**APPLICATION BY NATIONAL GRID ELECTRICITY TRANSMISSION FOR AN ORDER  
GRANTING DEVELOPMENT CONSENT FOR SEA LINK**

**PINS REFERENCE: EN020026**

**SUBMISSIONS ON BEHALF OF SAVE MINSTER MARSHES  
FOR ISSUE SPECIFIC HEARING 3 HELD ON 25-27 MARCH 2026  
AND DEADLINE 6**

Plate 2.4 Potential floodplain compensation provision locations

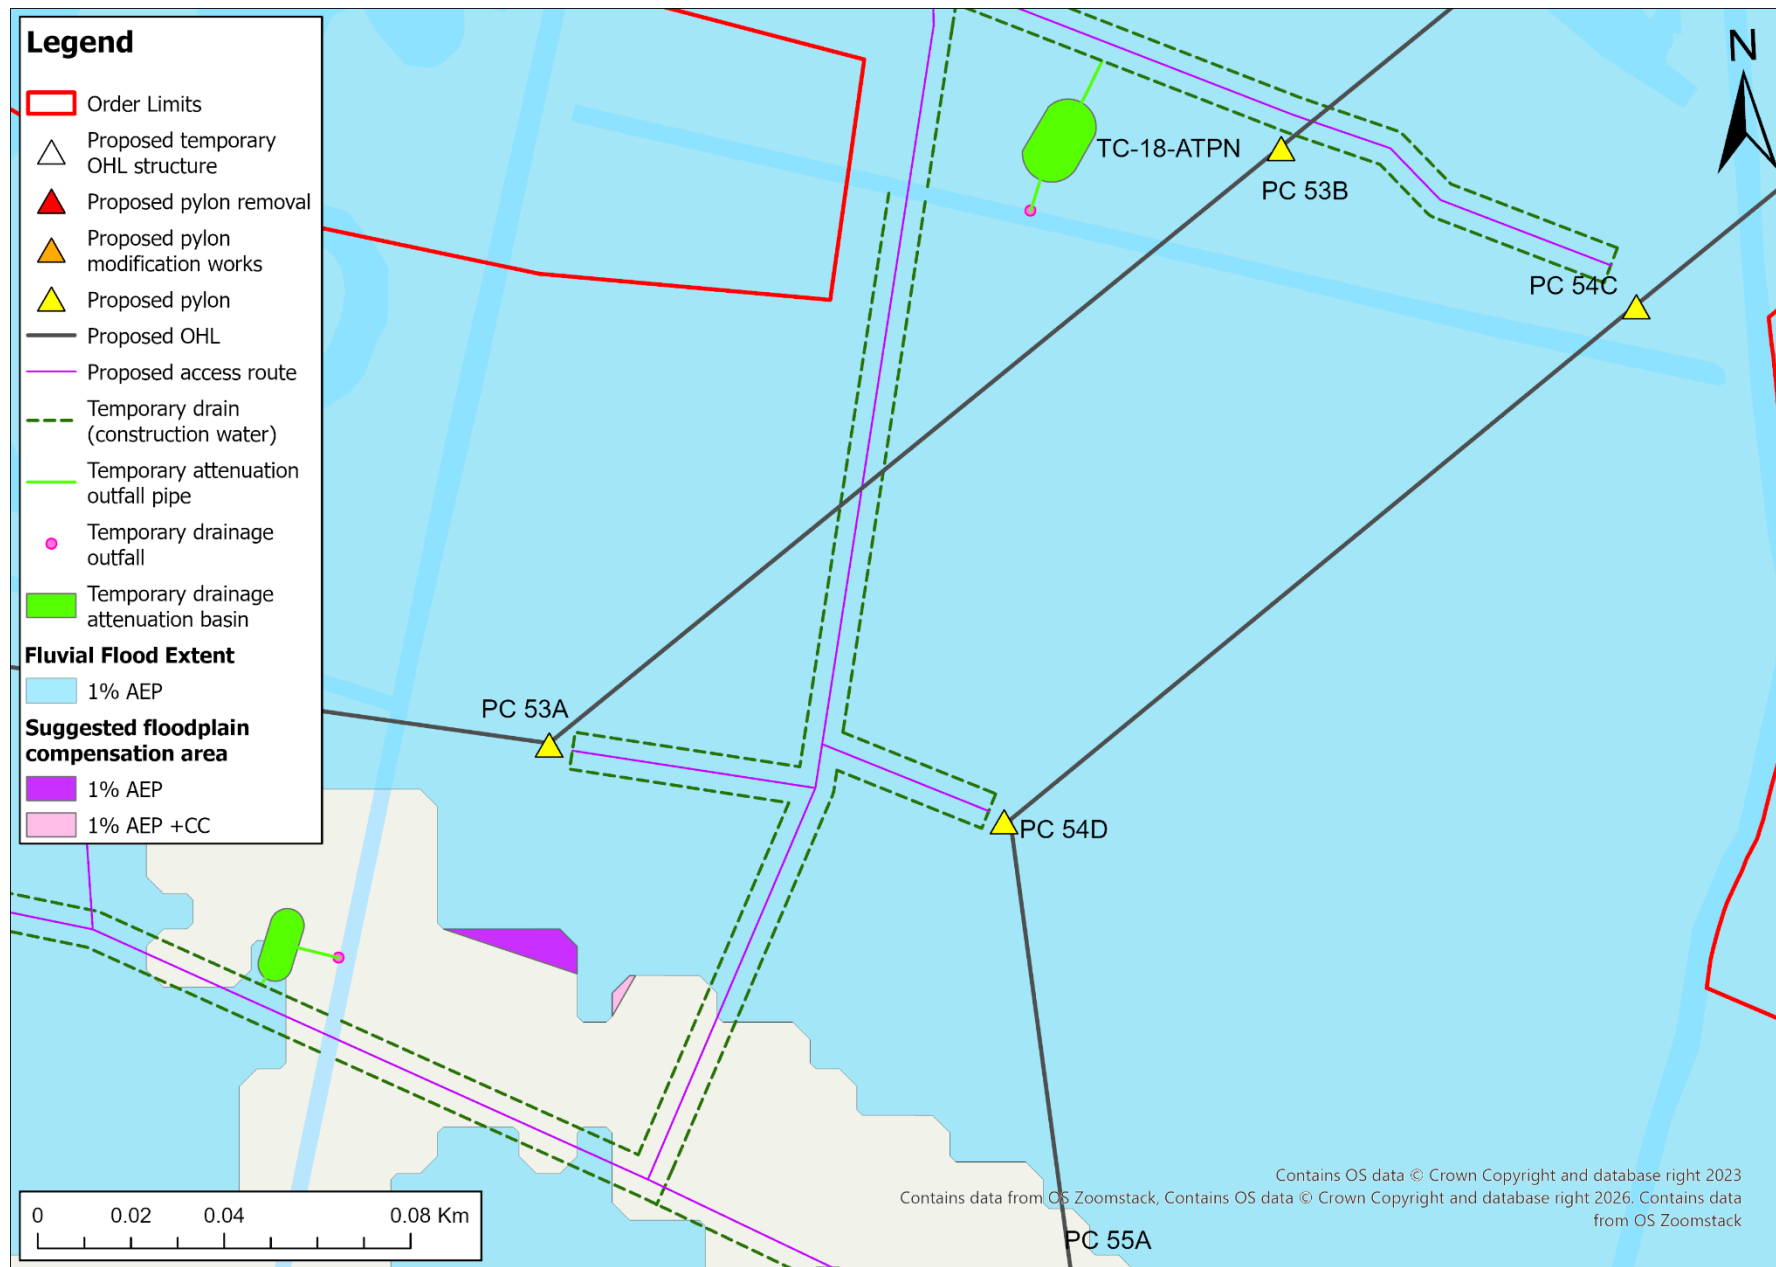
17. Document 9.101: Kent Onshore Scheme – Fluvial Flooding from the River Stour (**REP4-096**) addresses fluvial flooding but ignores groundwater flooding issues. Paragraph 2.3.2 states that final floodplain storage compensation proposals would be presented by the appointed contractor and secured through the REAC. SMM questions whether it is acceptable that floodplain compensation is still not planned at this late stage and is being left to the contractor to deliver post-consent.
